Project Name: Park Danforth

Project Address: 777 Stevens Ave.

February 11, 2015

Project Name: The Park Danforth                      Project ID: 2014-202  
Address: 777 Stevens Avenue                      CBL: 146 C005 001  
Applicant: The Park Danforth- Denise Vachon  
Planner: Shukria Wiar

2 THE SNOOT CAT GARAGE DRAINAGE STRUCTURES
NOT TO SCALE

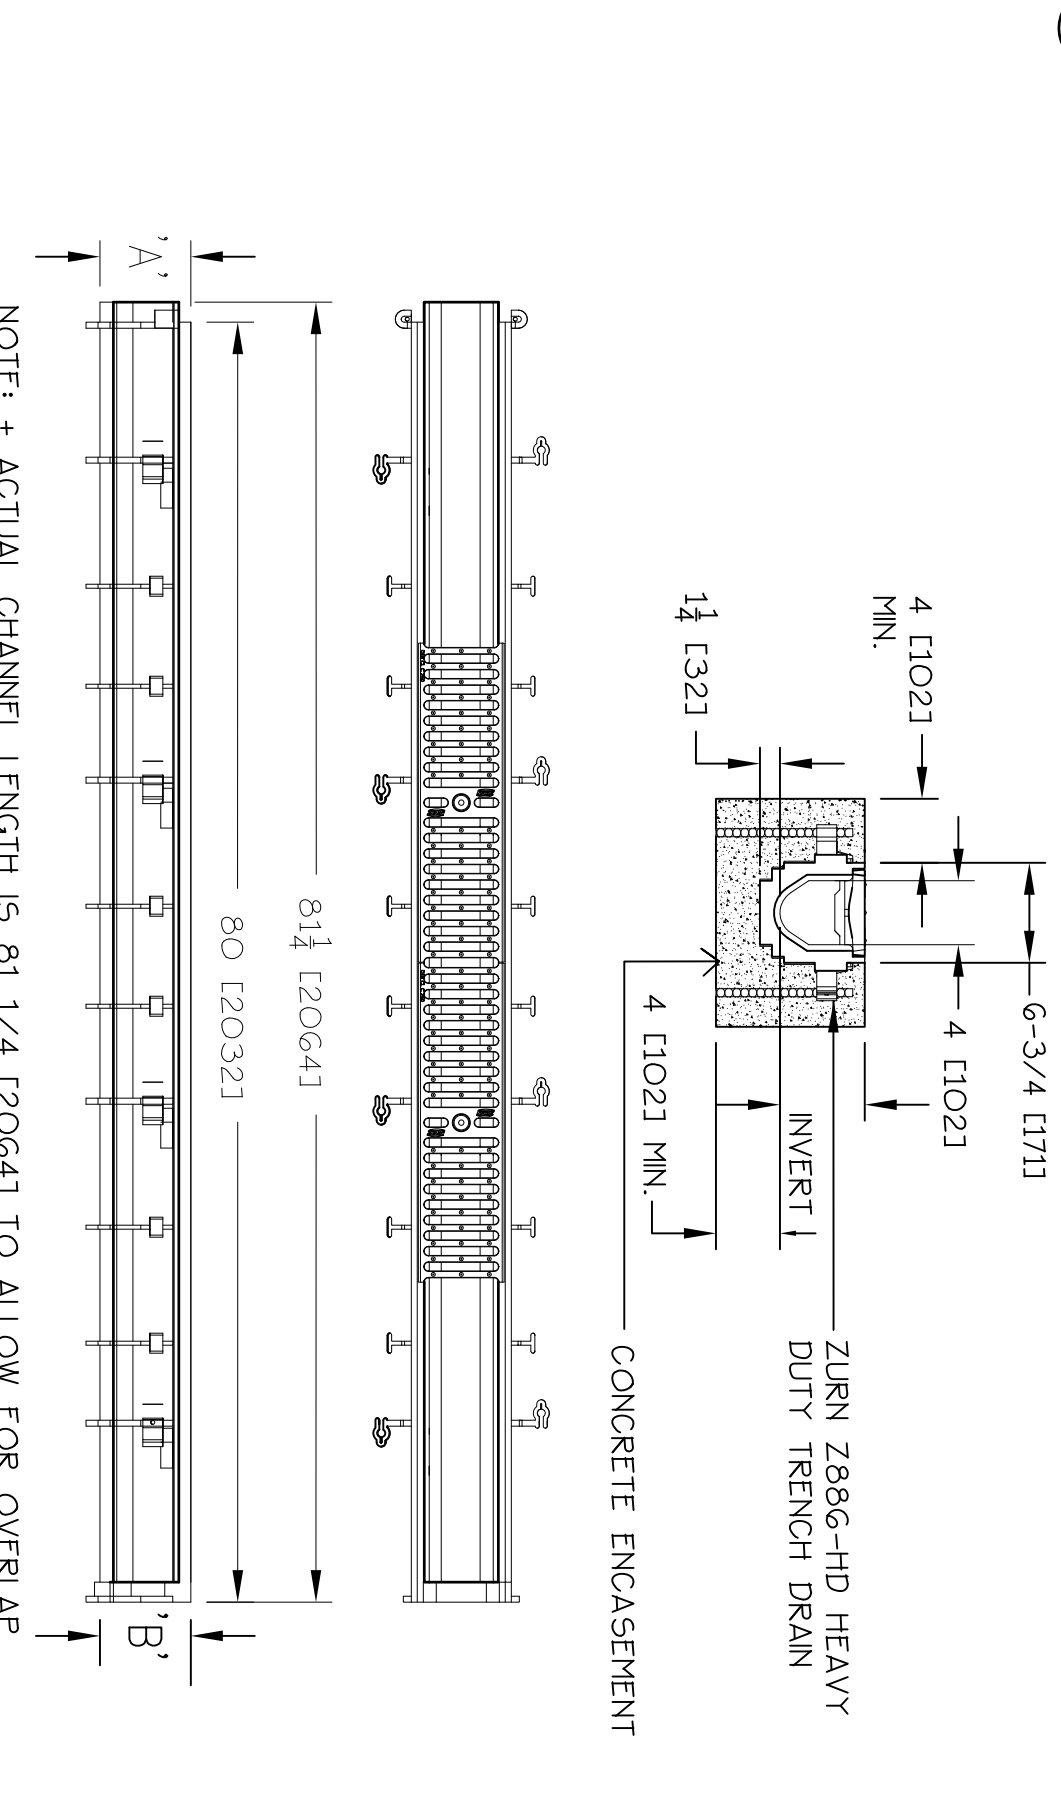
3. The Erosion and Sediment Control Plan (L3.2) shall be revised to identify an inlet sediment control device on existing CB# 4.
4. The note on the Snout detail shown on Sheet L6.2 which states "The Snout shall be provided on Proposed Catch Basins #6100, #6101 and #6102"; shall be deleted from the revised plans.

Drawing file: 4. Revised Plans / L2.1 Ramps 11-25-2014.pdf

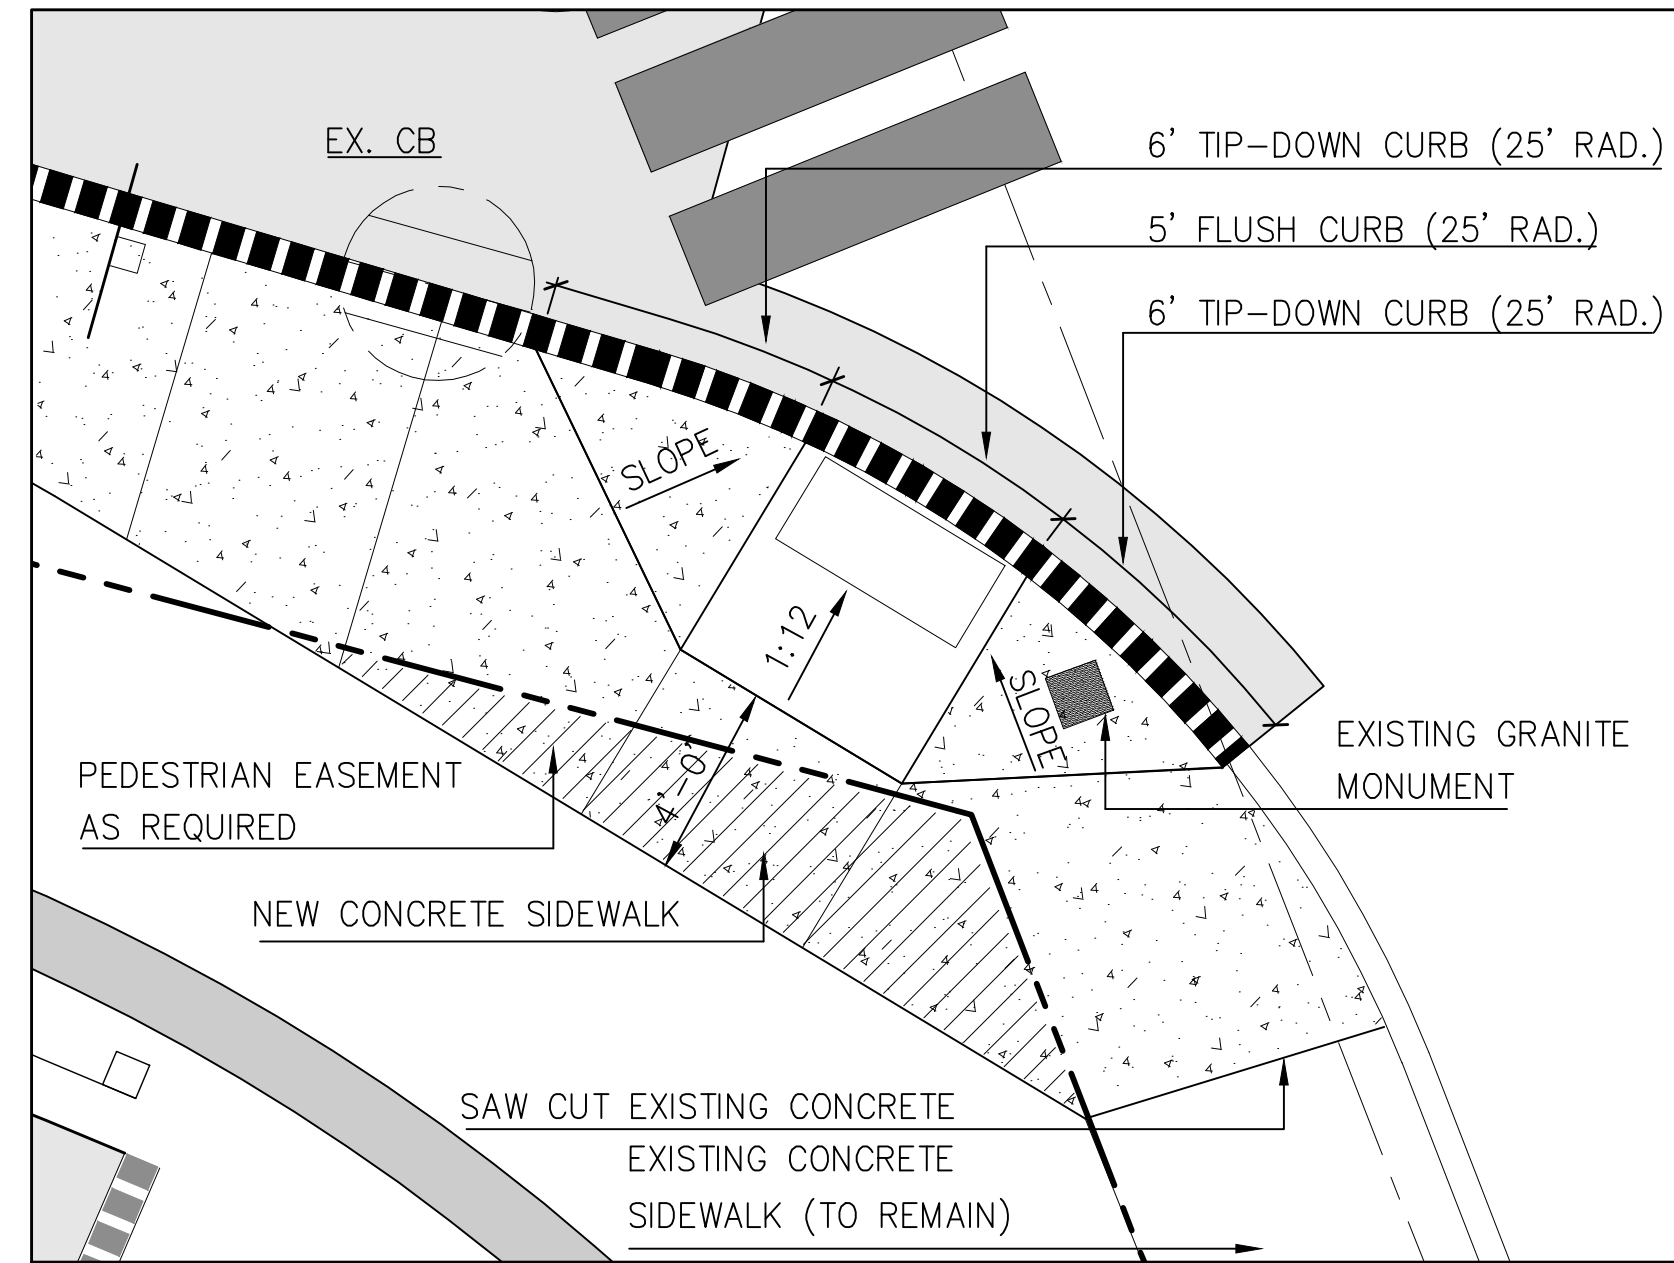
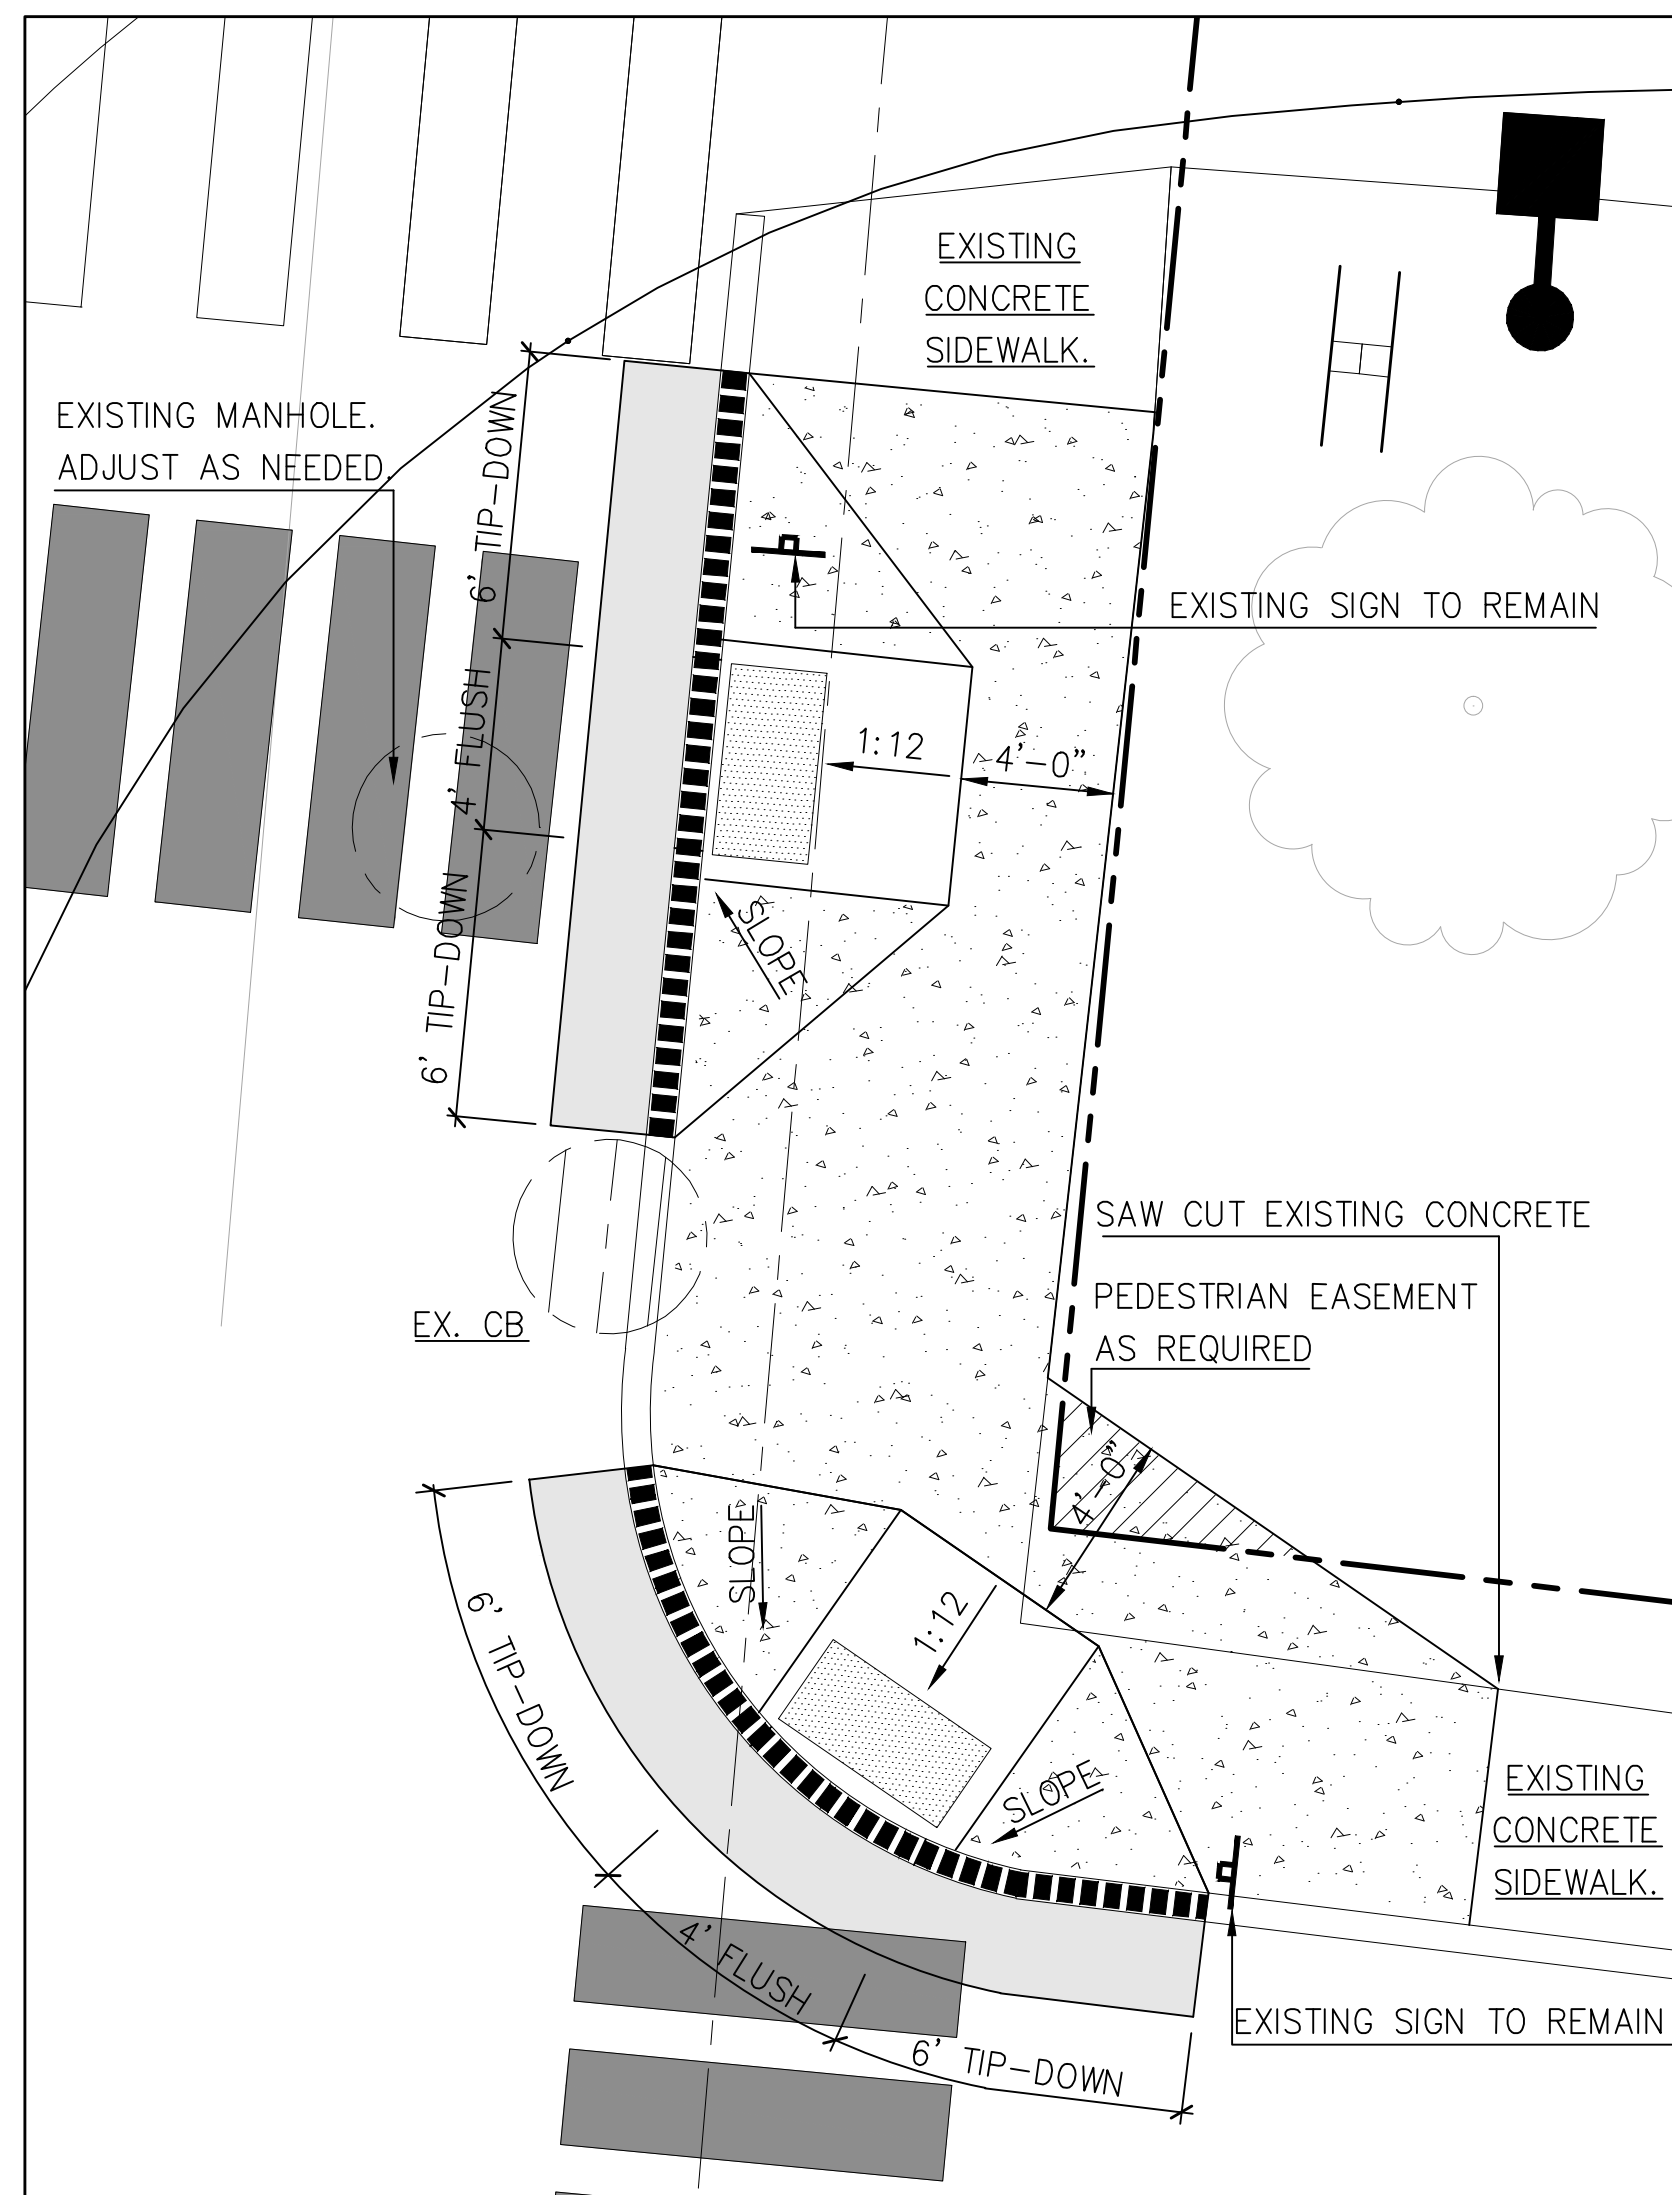
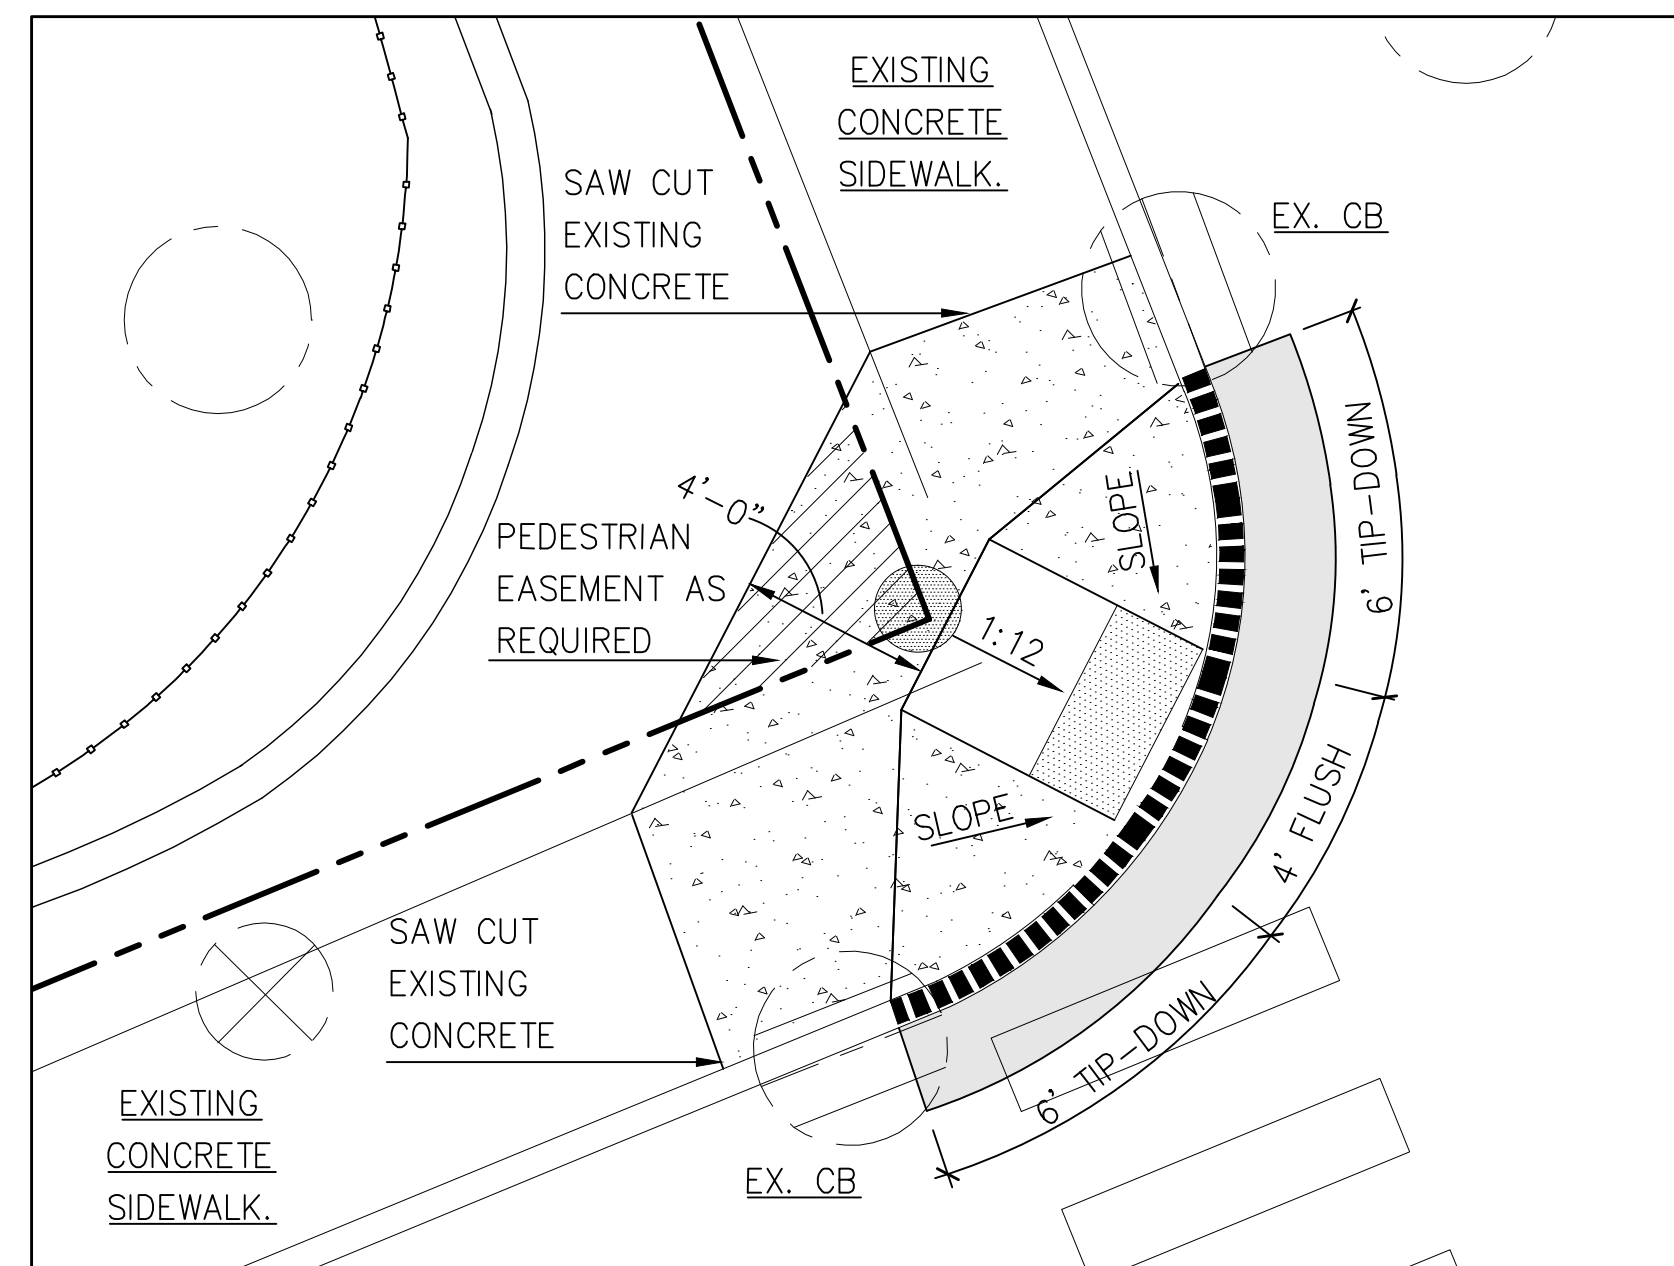
- ② The accompanying plans for the site plan shall be revised to reflect the changes contained in the overall site plan, including the plans for the fully ADA compliant crosswalk and ramps, and the plans shall be reviewed and approved by DPS, Fire, Traffic, and Planning prior to the issuance of a building permit. - PG
